Town & Country Planning Act 1990 (as amended)
Town and Country Planning (Development Management Procedure) (England) Order 2015
Application for approval of details reserved by condition imposed under BR/54/16/PL relating to
condition No. 7 (Construction management plan), 10 (Surface water drainage), 12 (Watercourse), 14
(External lighting scheme), 15 (Noise), 16 (Public sewers), 17 (Foul & surface water sewerage
disposal), 18 (Cars), 19 (Roof plant), 23 (Landscaping scheme), 24 (Tree retention & protection plan),
25 (Programme of archaeological work & scheme of investigation), 26 (schedule of materials) & 34
(Programme of ecological work)
University of Chichester Upper Bognor Road, Bognor Regis,

Condition Number 16

Arun District Council have decided to **REFUSE details reserved by condition for the following reasons:**

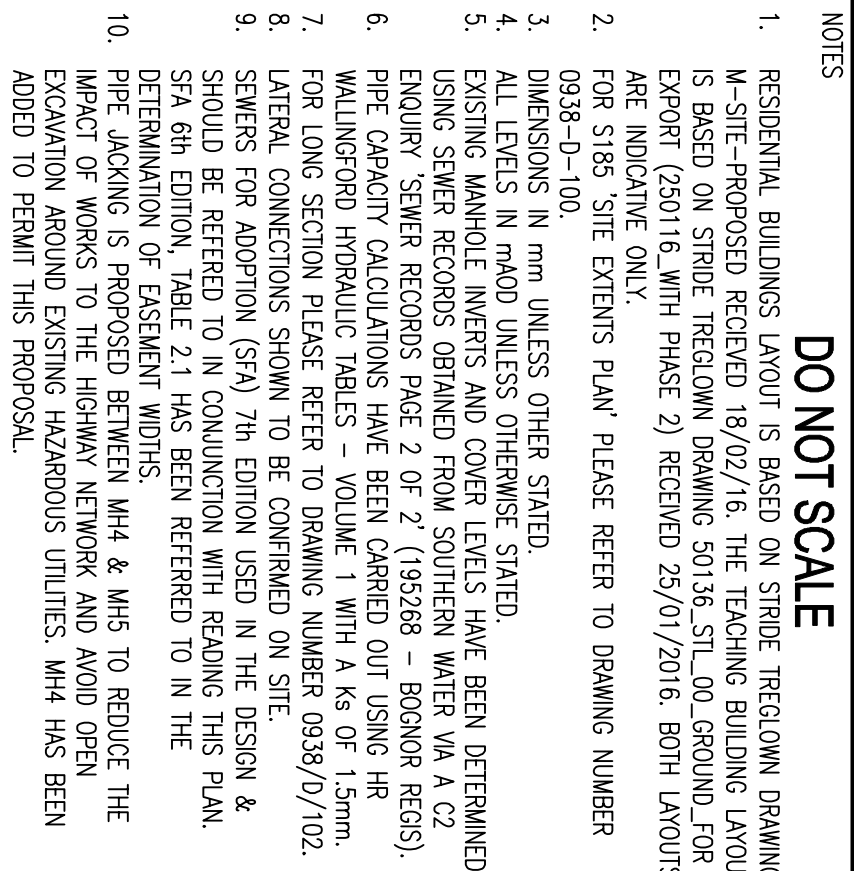
The sewer diversion proposals should be agreed and approved by Southern Water under s185 of the Water Industry Act before condition 16 can be discharged.
